WELWYN HATFIELD BOROUGH COUNCIL – DEVELOPMENT MANAGEMENT
DELEGATED REPORT

APPLICATION No: S6/2013/2530/FP

SITE ADDRESS: Ramada Hatfield, St Albans Road West, Hatfield

DESCRIPTION OF DEVELOPMENT: Change of use of land to car washing, valeting (sui generis), works to include erection of a canopy

1:50 CANOPY PLAN

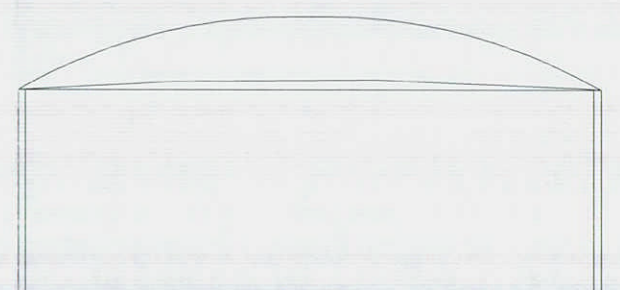
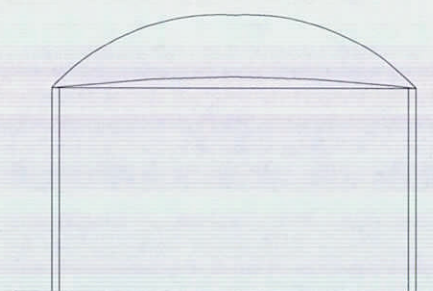
In terms of design and materials, the canopy appears to be constructed from galvanised steel support posts and roof arches which are covered by PVC coated fabric. The fabric roof is bright orange in colour. In terms of design and materials, the canopy appears to have been designed to draw attention to the proposed car wash with little regard to the visual amenity of the streetscene or its impact on the setting of the adjacent listed building. The canopy which has already been erected on the site appears incongruous within the streetscene given its scale, prominence and design, which has paid no attention to the surrounding built form. The proposal would detract unacceptably from the appearance of the Grade II listed building resulting in substantial harm to the setting of this building. Accordingly the proposal fails to comply with Local Plan Policies D1 and D2 and the National Planning Policy Framework.

Given the scale, height, design and siting the proposed canopy, the development would appear as a prominent and incongruous addition within the streetscene. In addition, the proposal would result in material harm to the setting and visual amenity of the adjacent Grade II listed building. The proposal therefore conflicts with Policy D1 and D2 of the Welwyn Hatfield District Plan 2005 and the National Planning Policy Framework. The listed building has an existing viable use as a hotel and no evidence has been submitted to suggest that the proposal would secure any investment in the buildings fabric. It is therefore concluded that the limited benefits of the development would not outweigh the harm to the significance of the listed building.

1. The applicant has failed to demonstrate to the satisfaction of the Local Planning Authority that the proposed development would not have a detrimental impact on the character and appearance of the application site or the surrounding area. Given the scale, height, design and siting the proposed canopy, the development would appear as a prominent and incongruous addition within the streetscene. In addition, the proposal would result in material harm to the setting and visual amenity of the adjacent Grade II listed building. The proposed development would therefore not be compatible with the maintenance and enhancement of the character of the area and it would not preserve the setting of the area or make a positive contribution to the character and local distinctiveness of this locality. As such the proposed development would be in conflict with Policies D1 and D2 of the Welwyn Hatfield District Plan 2005 and the National Planning Policy Framework.
